Please find attached the latest revised version of the drawing for the proposed Garage that refers to the proposed replacement tree to the SE corner of the site, approved under application reference R/271/19/T.

Further to our discussions, please find attached a revised garage design which incorporates the following:

183038/ 07

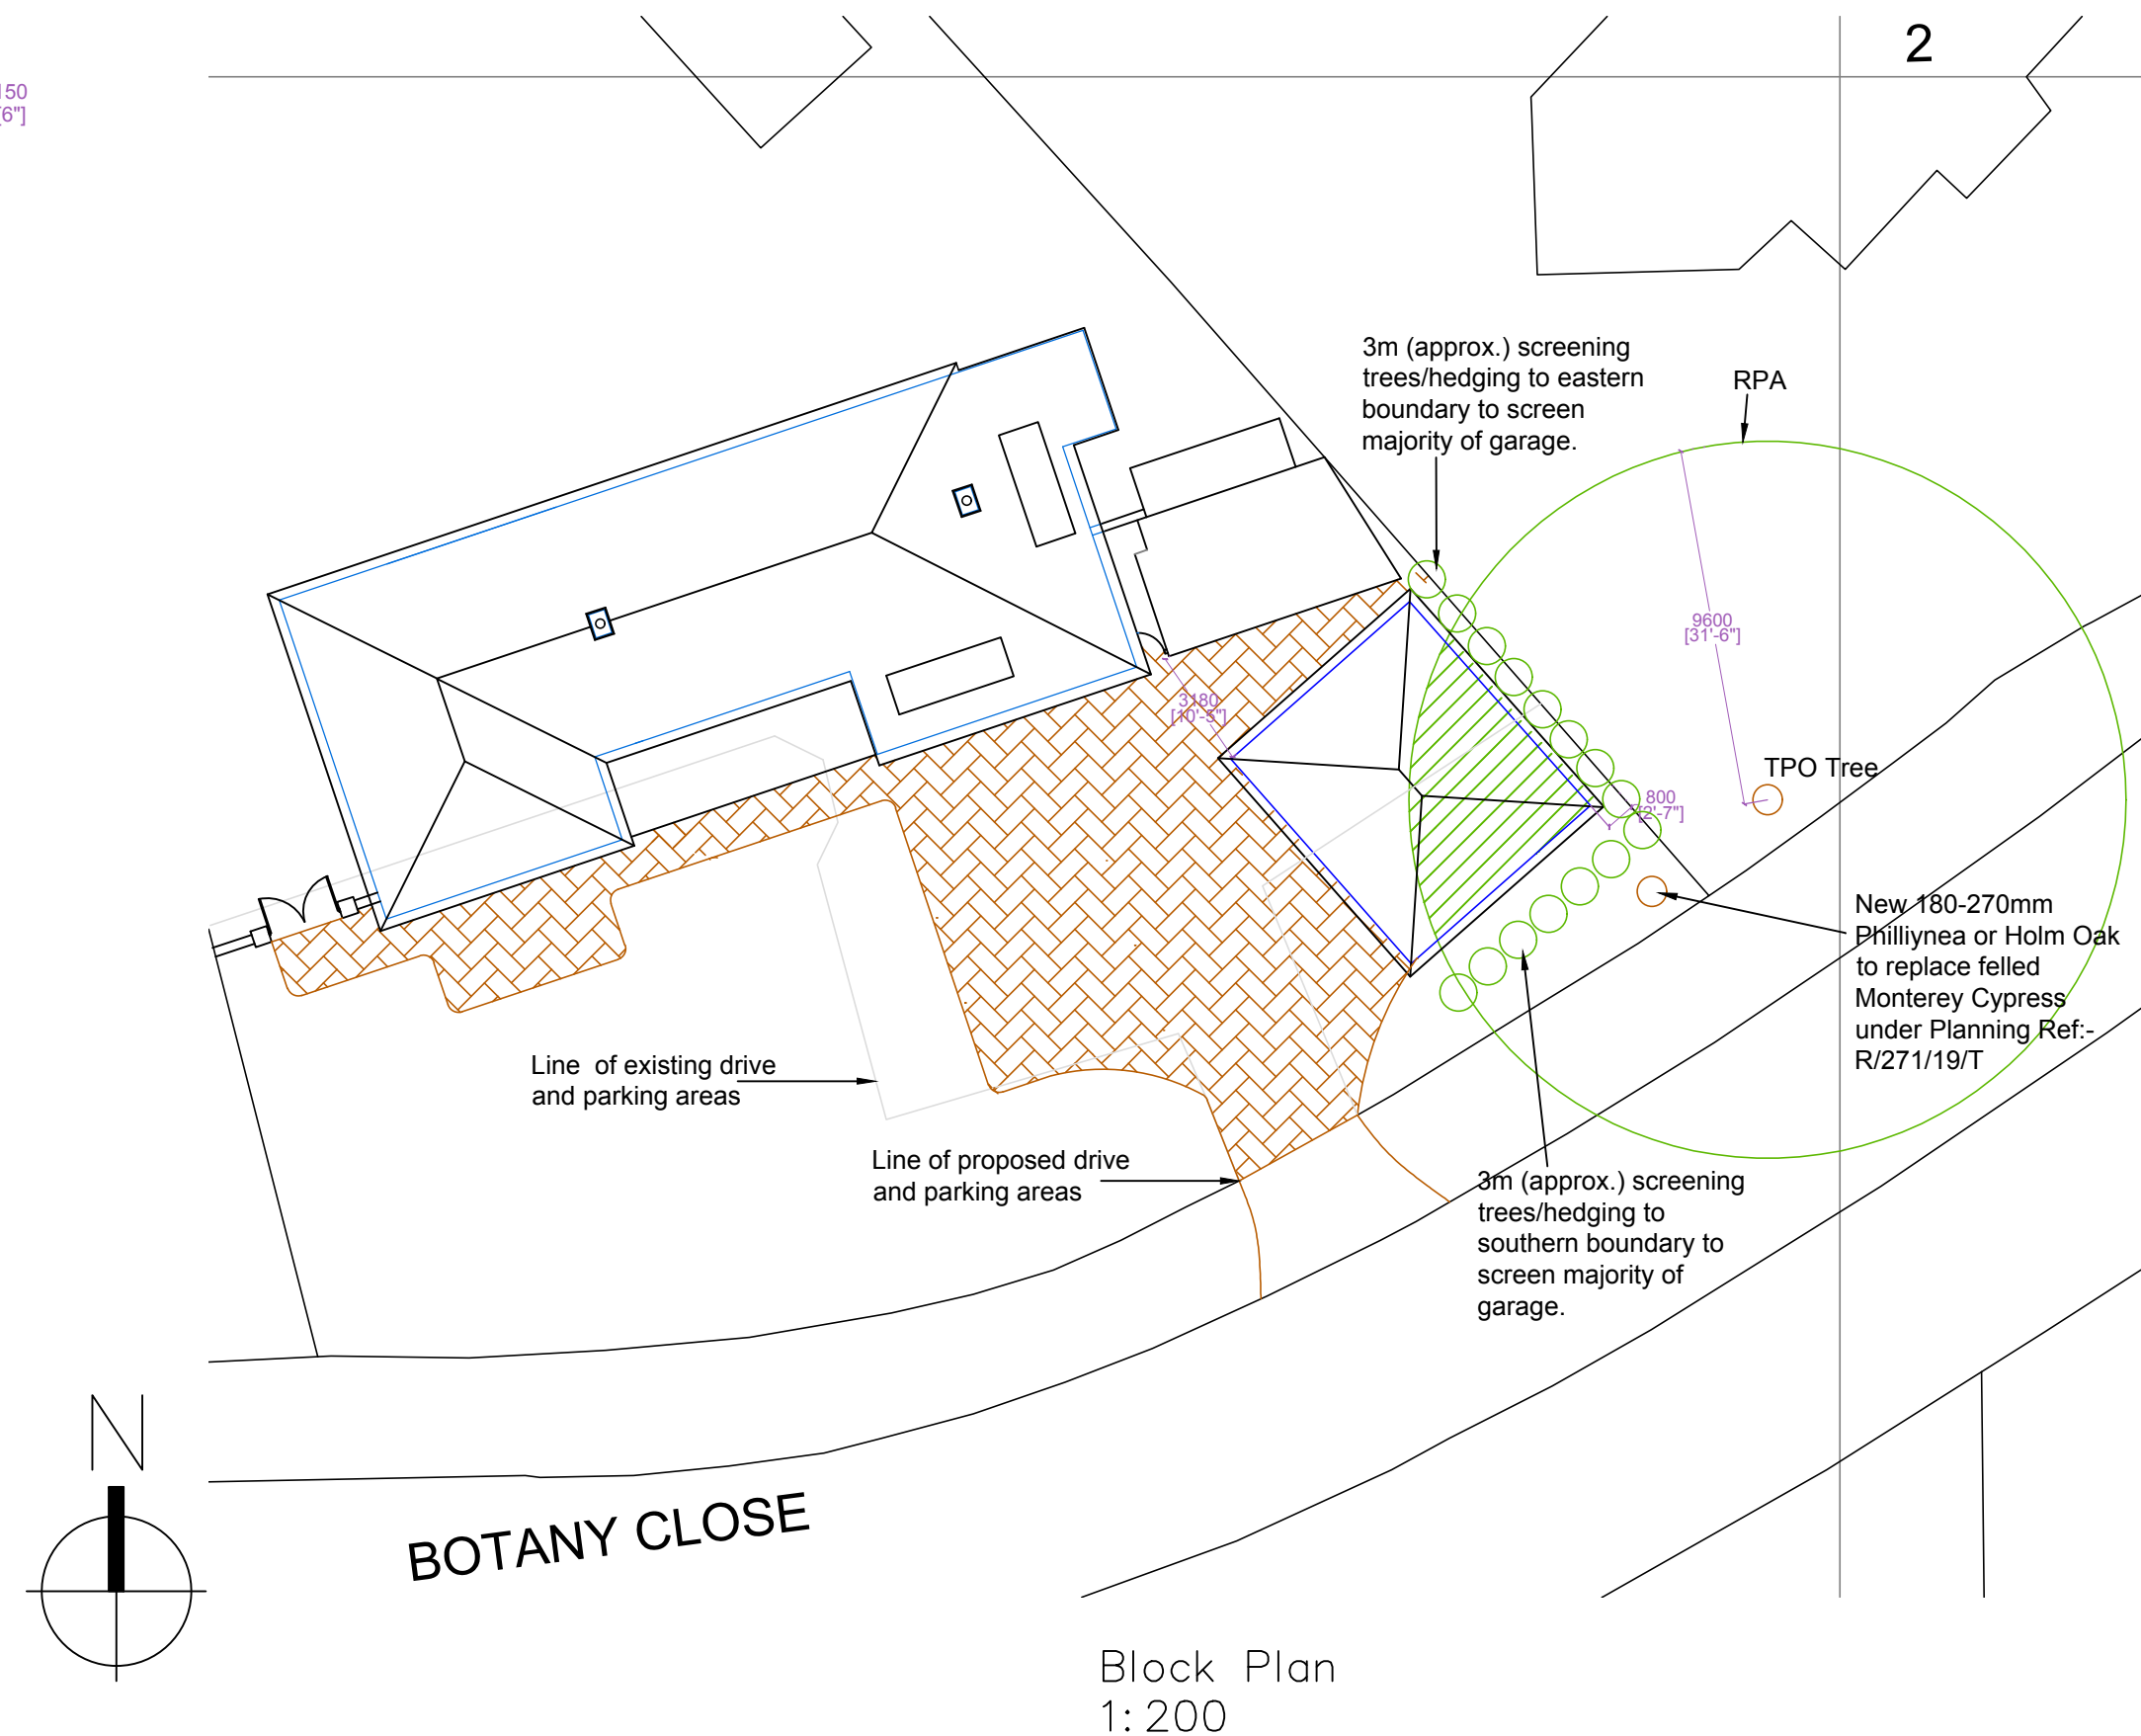
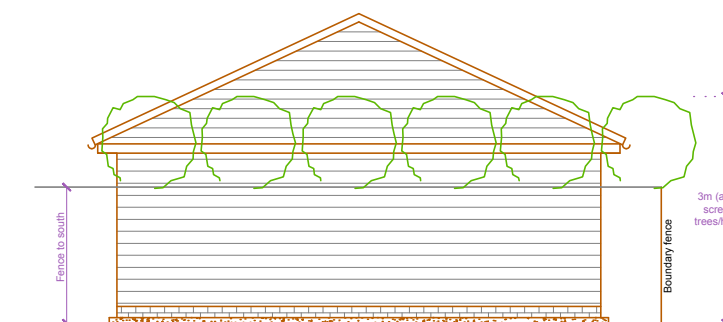
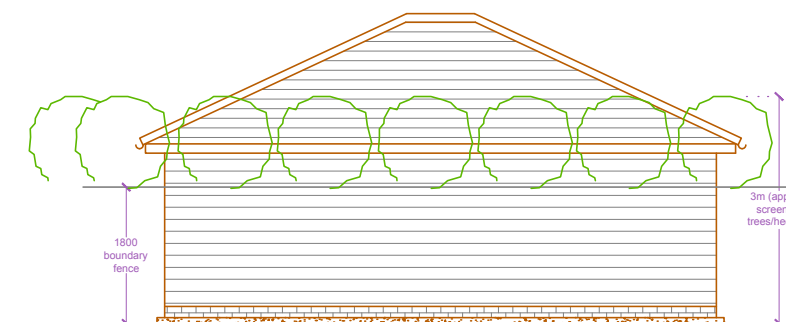
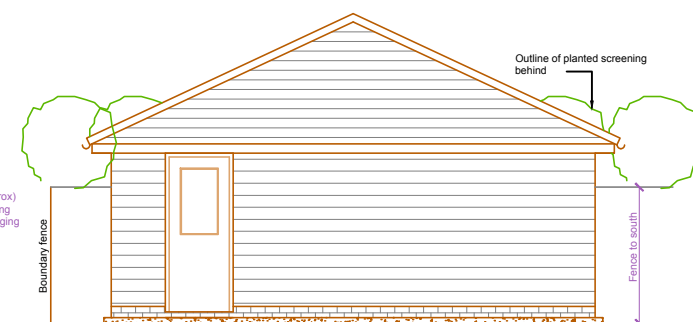
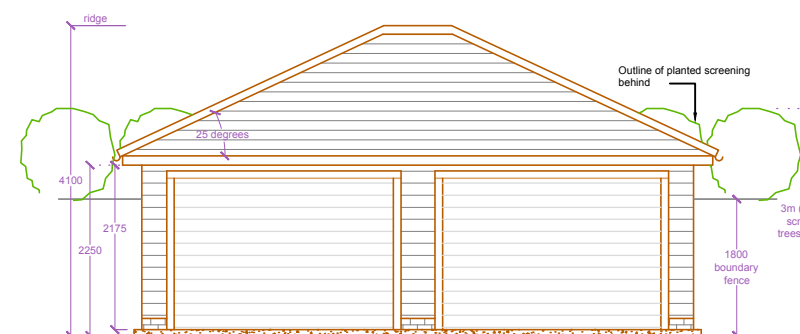
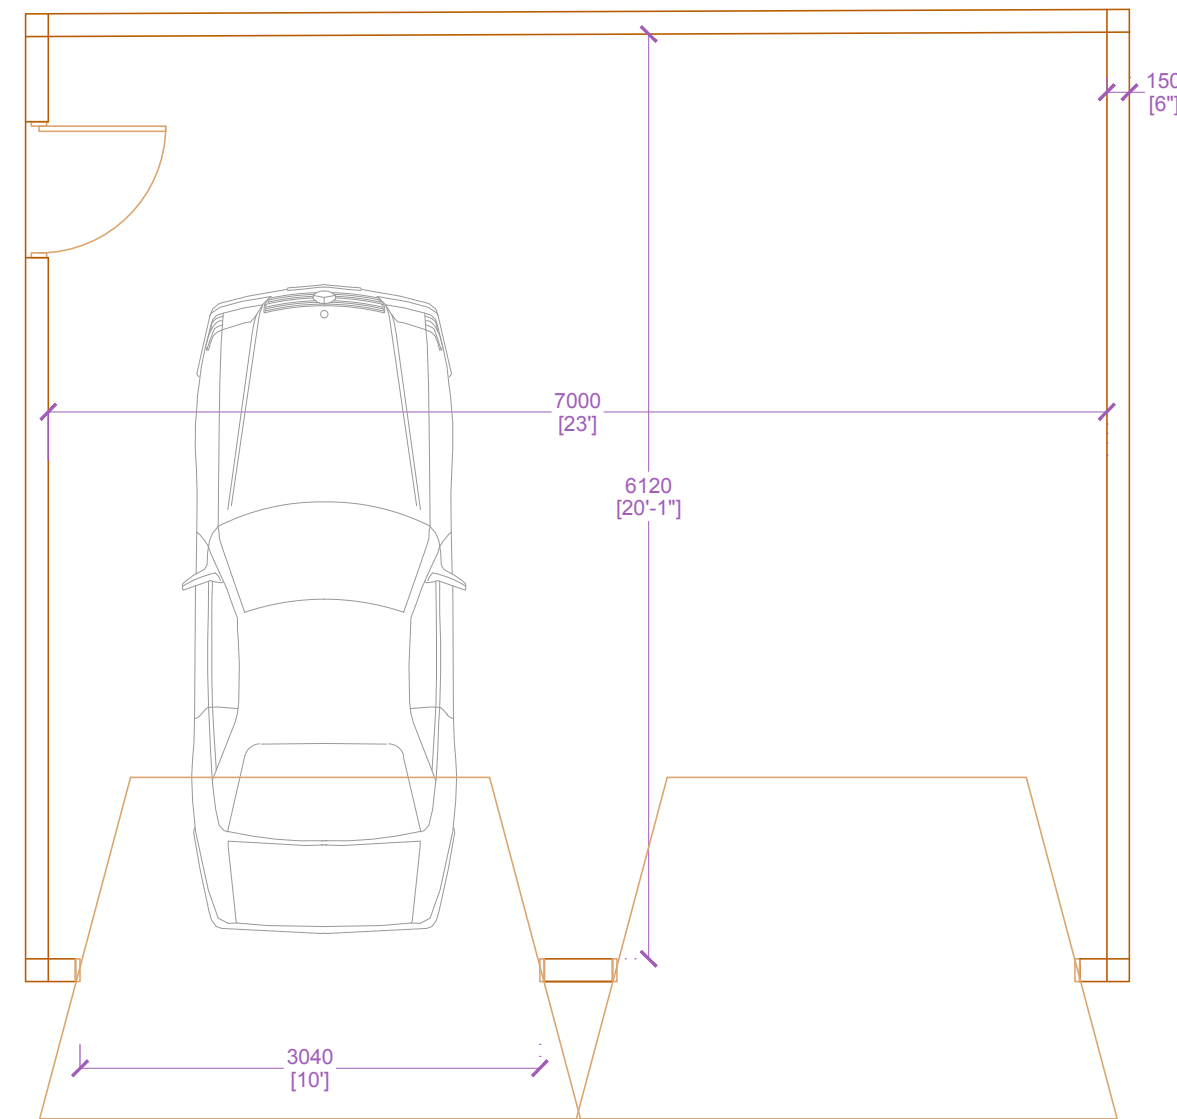
- 1) The pitch of the roof has been reduced resulting in a reduction in the ridge height and overall mass of the roof.
- 2) The proposed materials have been varied from facing brick and interlocking tiles to match the house, to softwood featheredge weatherboard and brown plain clay tiles, to more subtly blend visually with the surroundings.
- 3) Landscaping to the South and Eastern boundaries has been added to screen the majority of the garage, which now sits more sympathetically within the streetscape.

I would note that the approved new Holm Oak tree proposed as the replacement for the now felled Cypress under application reference R/271/19/T, will form part of the landscaping to the Southern boundary.

The view of the Planning Department is that both of the changes should be implemented (the materials, and the landscaping), as it is felt that these changes are likely to mitigate the potential for harm to the area.

I have spoken with my Team Leader and we are happy to go forward with the scheme as you have proposed it in the attached plan.
